**KITTITAS COUNTY**  
**DEPARTMENT OF PUBLIC WORKS**

**MEMORANDUM**

**TO: All Staff**  
**FROM: Public Works Plan Review Team**  
**DATE: November 10, 2022**  
**SUBJECT: LP-22-00004 Suncadia Ph 1 Div 14**

JOB NO.:	998-768-017
DWG. NAME:	PP-01
DESIGNED BY:	JJH
DRAWN BY:	LGB
CHECKED BY:	
DATE:	08/16/2022
PRINT DATE:

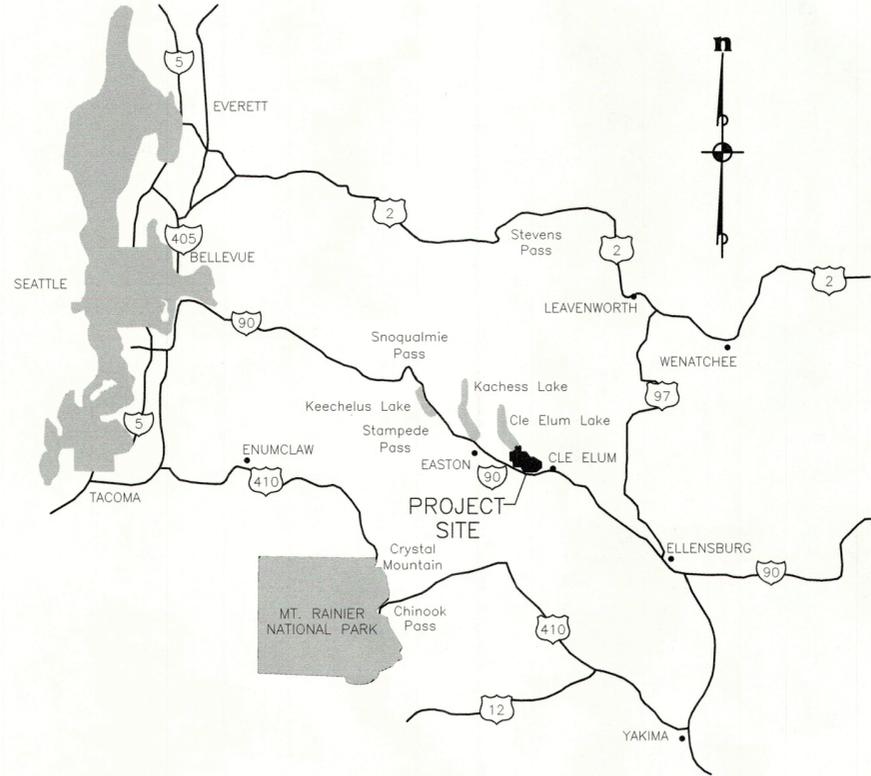
<b>SURVEY (KH)</b>	<p><b>Updated survey comments as of 11/17/2022</b></p> <p><u>Sheet 1</u></p> <ol style="list-style-type: none"> <li>4. Utilities, sewer, stormwater, and road cut/fill slope easements should be contemplated. All easements shown upon referenced conceptual and preliminary documents shall be included on the face of the Plat per KCC 16.12.110</li> </ol> <p><u>Sheets 2 and 3</u></p> <ol style="list-style-type: none"> <li>6. Include ownership, width and surfacing for Big Hill Drive (EX: 60' wide Private R/W - Paved)</li> <li>8. Lots OS-1, 37, 38 and 39 all have portions of a prior Open Space parcel (OS-3, Plat 11-78). Development of open Space should be resolved with CDS.</li> </ol>
<b>FLOOD</b>	<p>The Amended Plat (11-2-2022) satisfies KCC 14.08.220 requirements that all subdivisions shall show on the face of both the preliminary and final plat, for either short or long plats, the boundary of the 100-year floodplain and floodway (AT 11/7/2022).</p>
